Application no: H14-0452-10

Description: Details submitted relating to Conditions 4, 7, 8, 9, 10, 11 and 12 of H14-0820-08)

Location: 20 Bear Lane
Pinchbeck
Spalding
Lincs
PE11 3XA
PE11 3XA

Amendment: Kitchen window to Flat 2 omitted and brickwork type amended (dwg. no. 1608-01C)

1608 - 01"B"

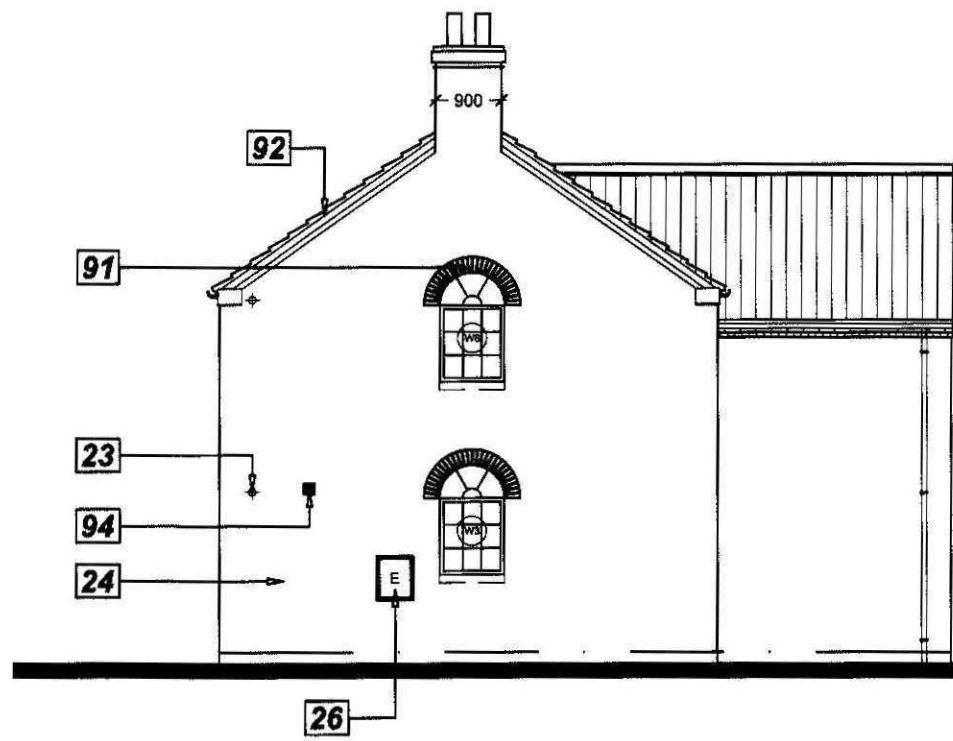
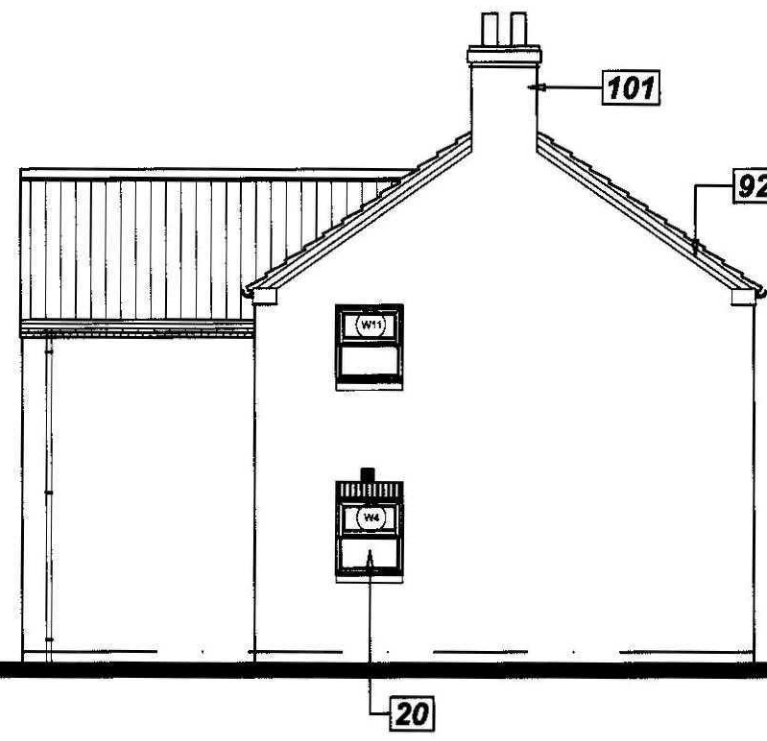
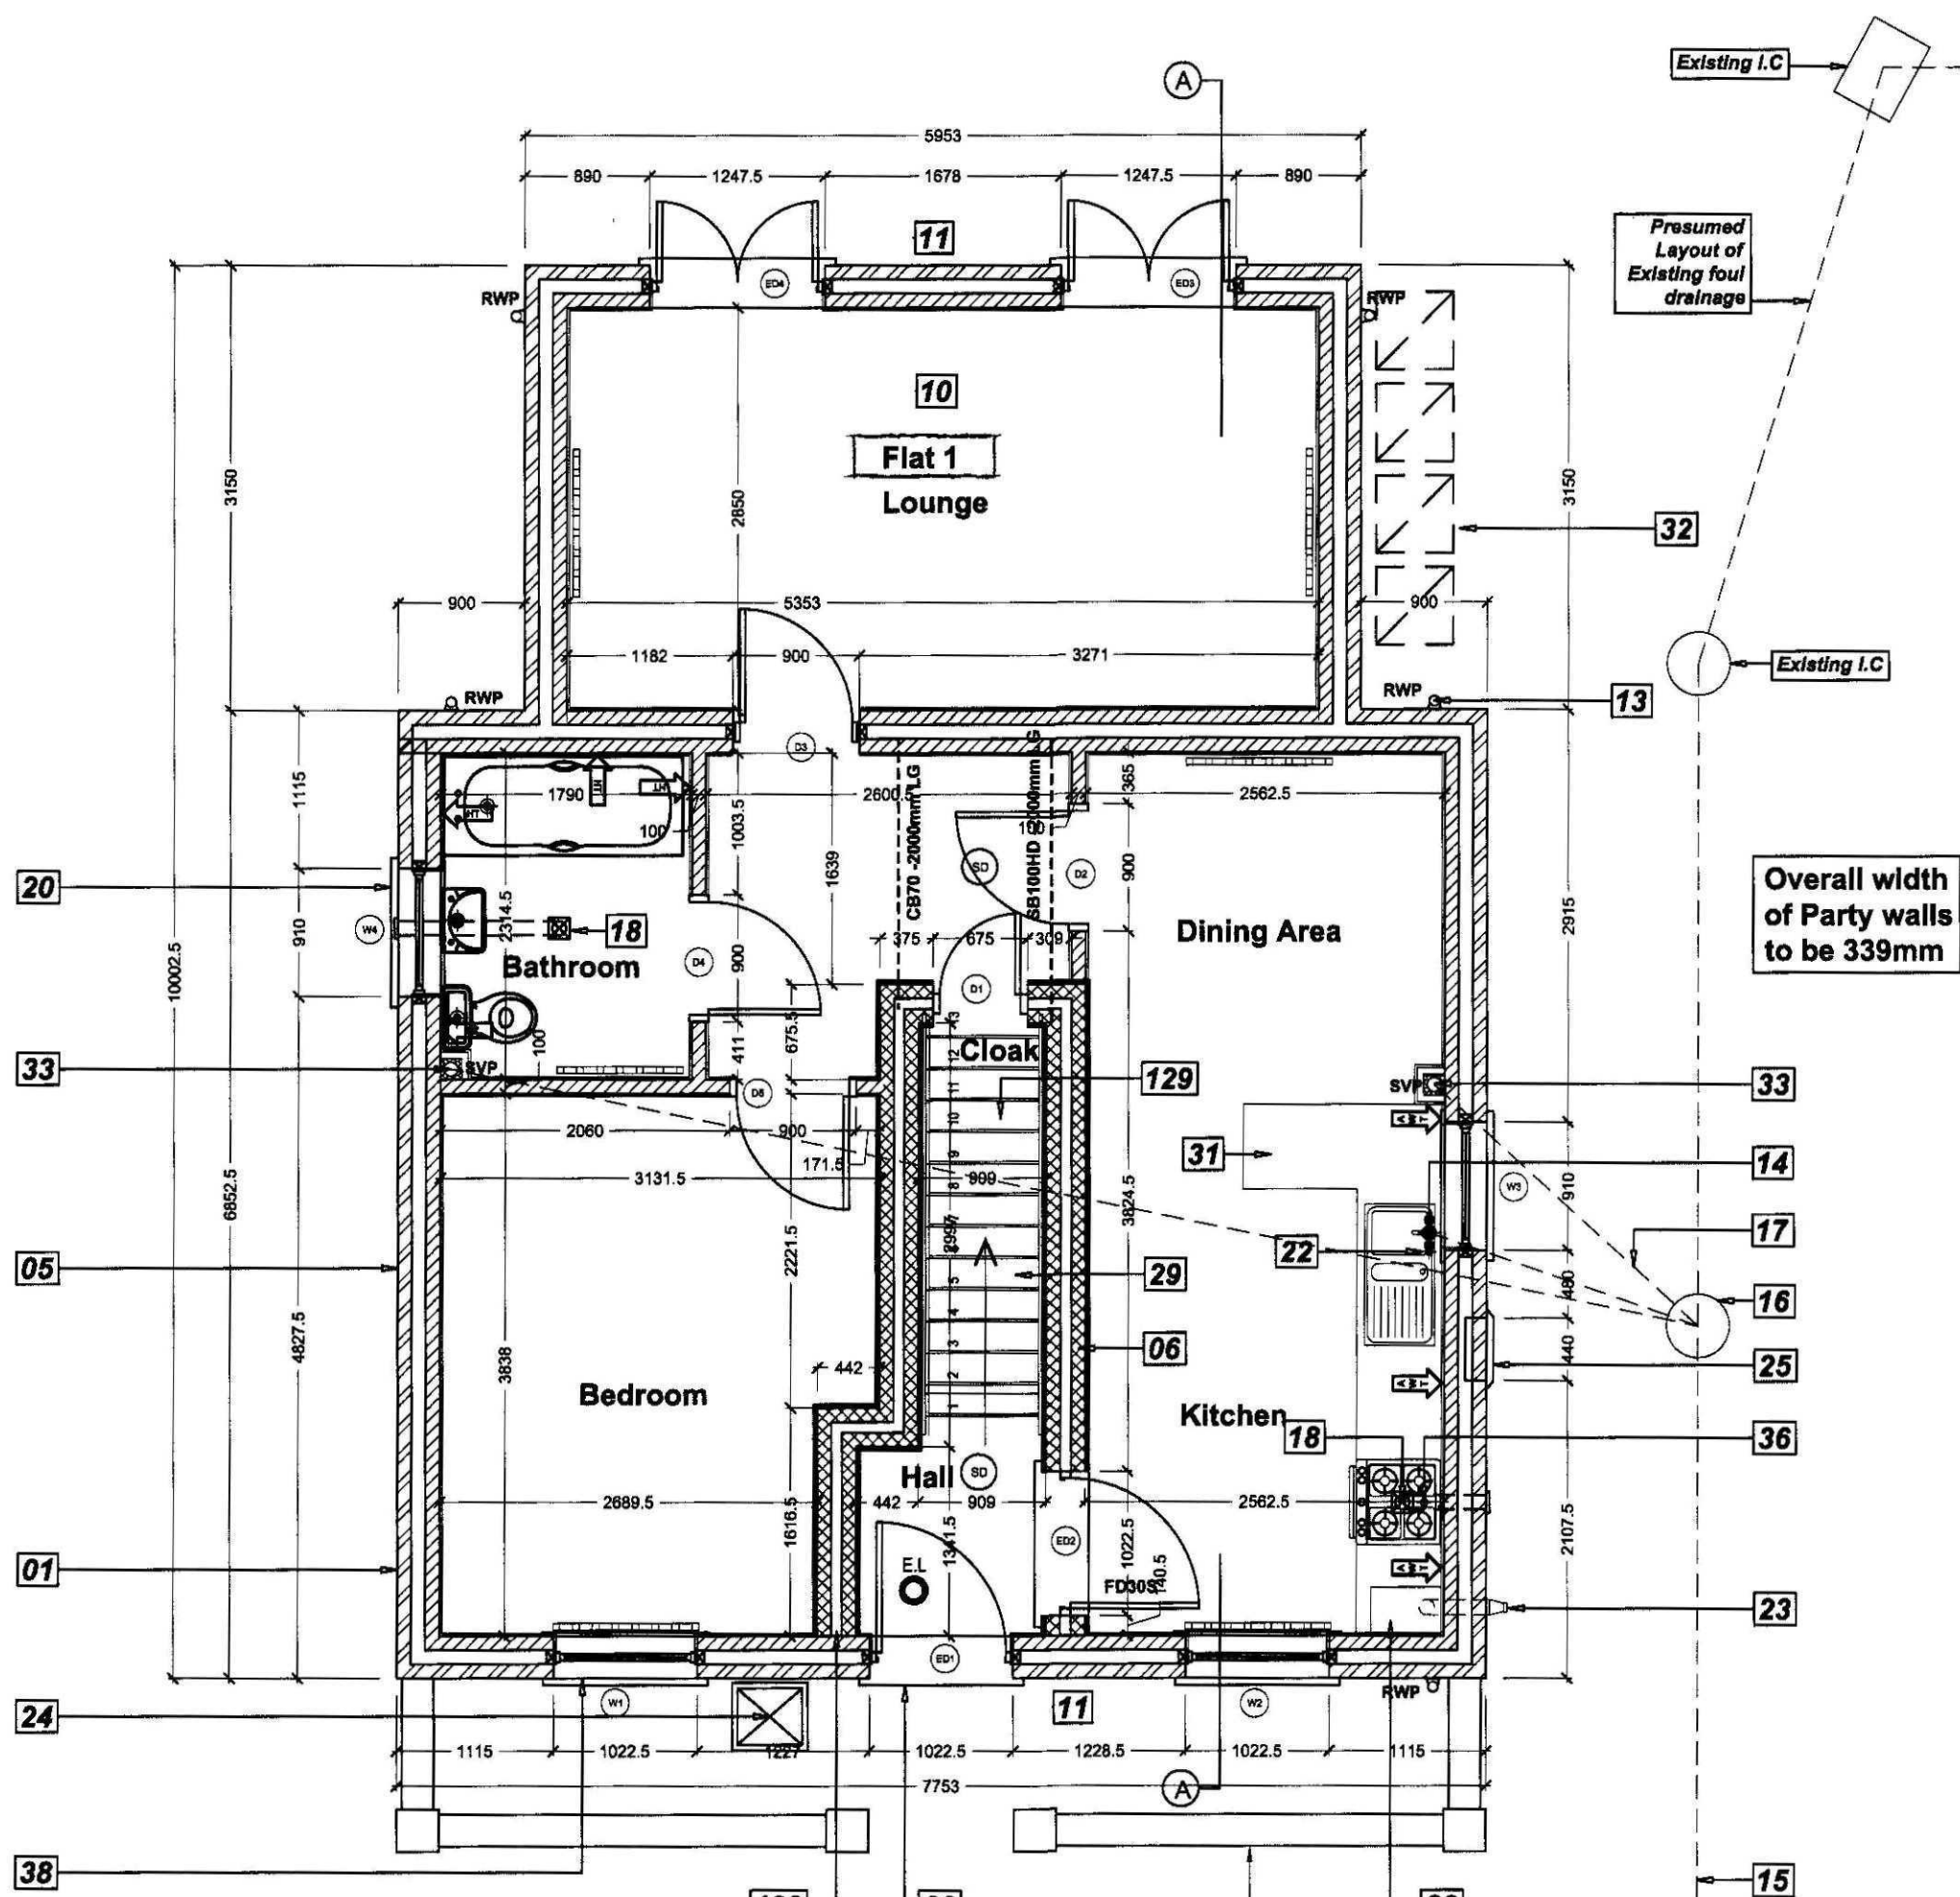
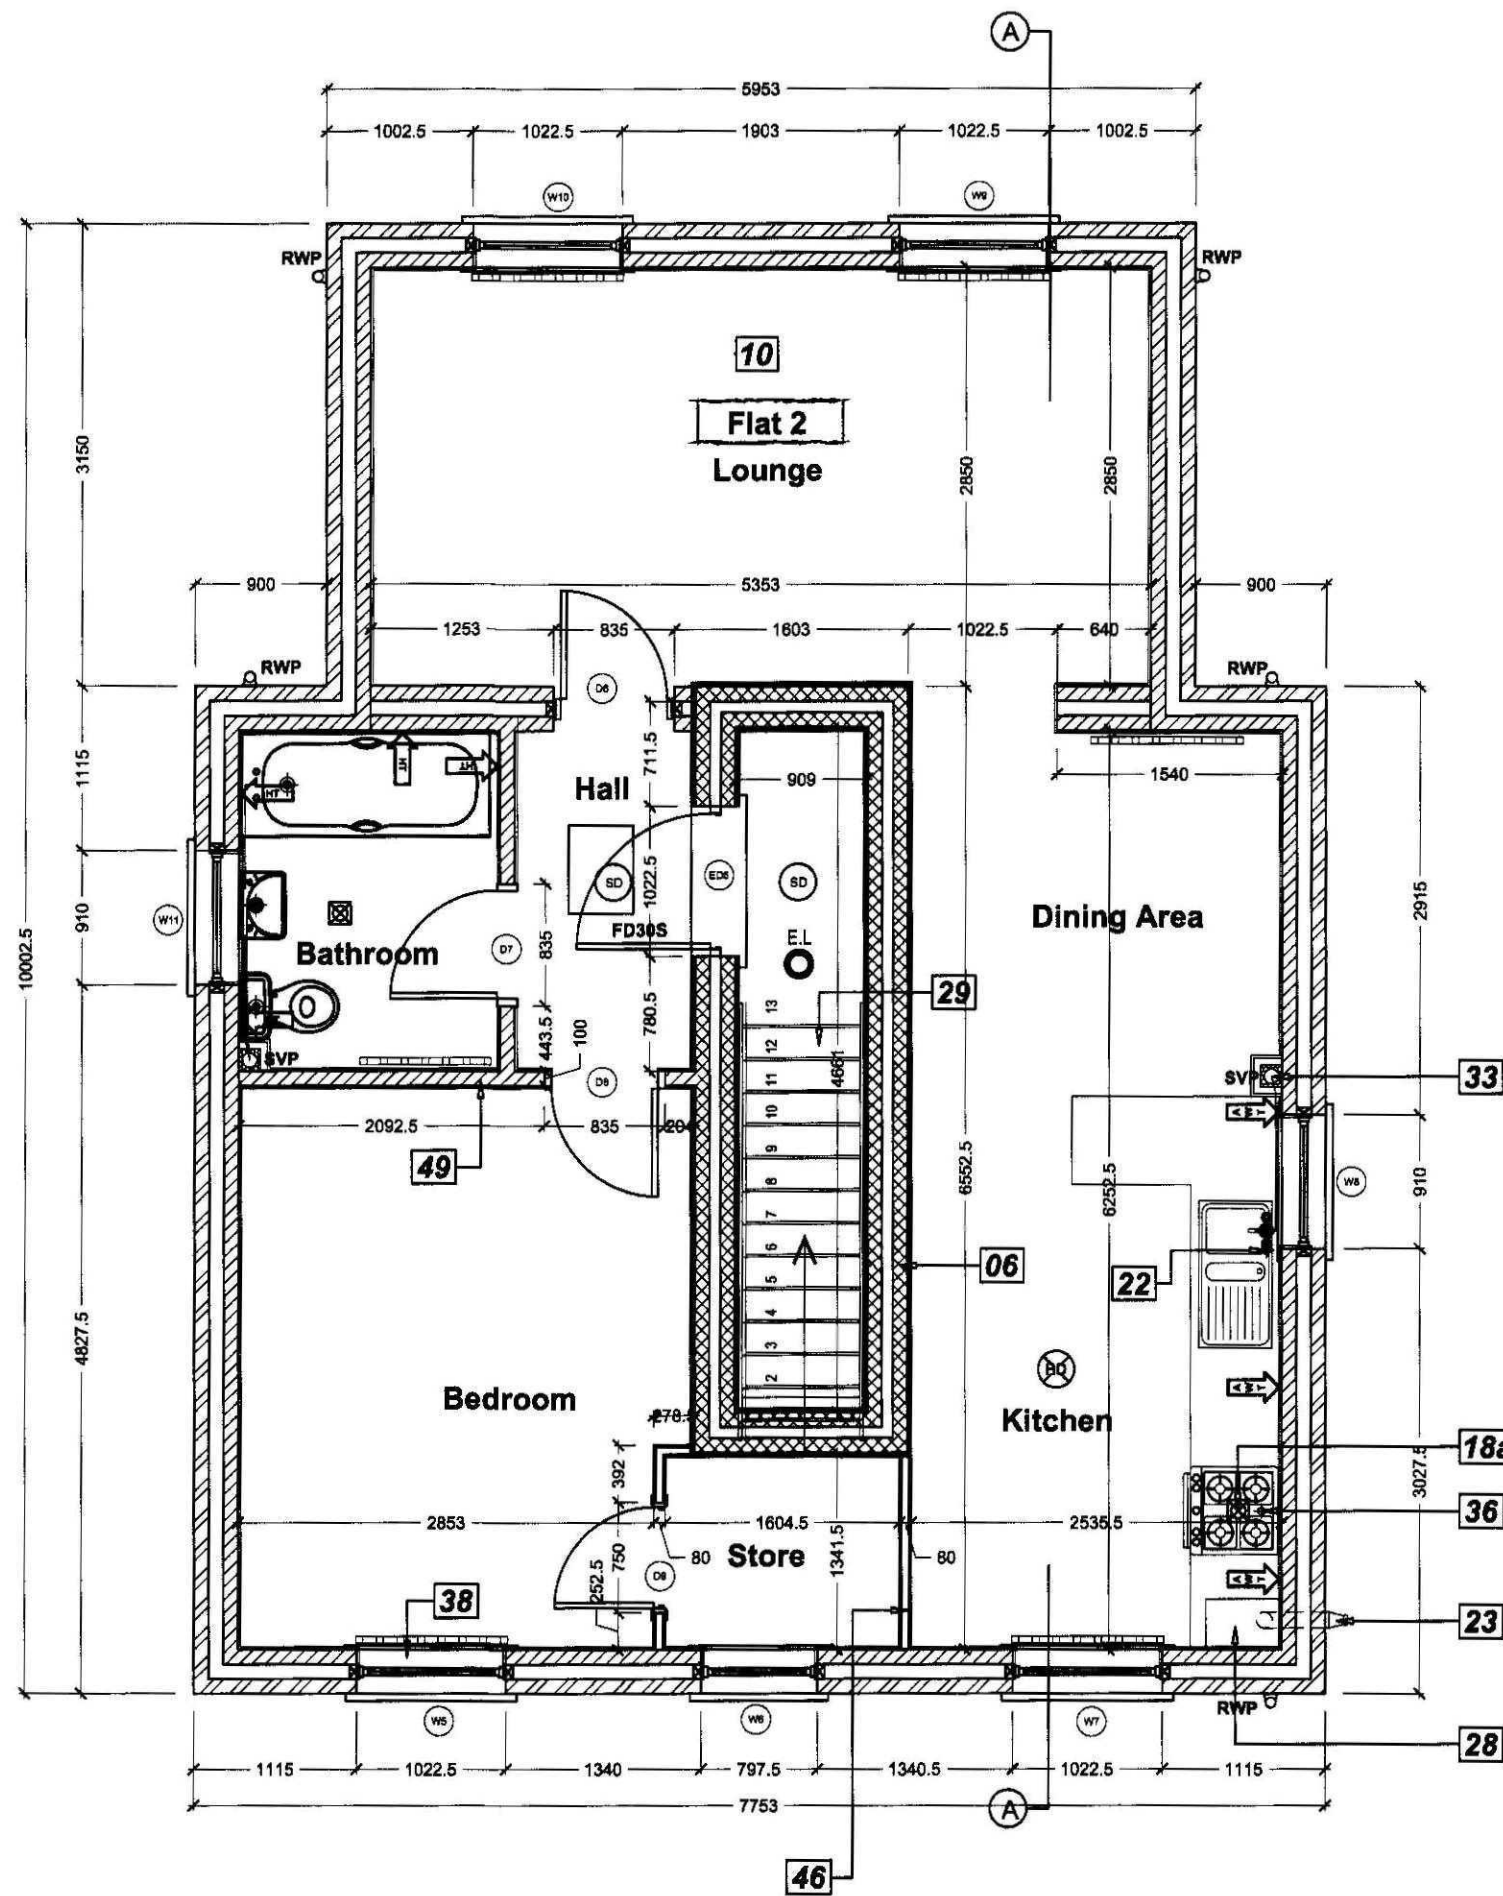
I'm afraid I've picked up on something else that will need to be addressed with this one. Comparing the elevations submitted as part of this con. comp. with the original planning application it appears that window 8 to the kitchen of flat 2 has been added. This wasn't shown on the originally approved elevations. To rectify this I can only advise that your client submit a revised planning application, since it will not be possible to accept as a non-material amendment given that it would potentially increase overlooking of the neighbouring bungalow.

We attach our amended drawing showing Revised Facing Brick Type and the omission of the Kitchen window to Flat 2.
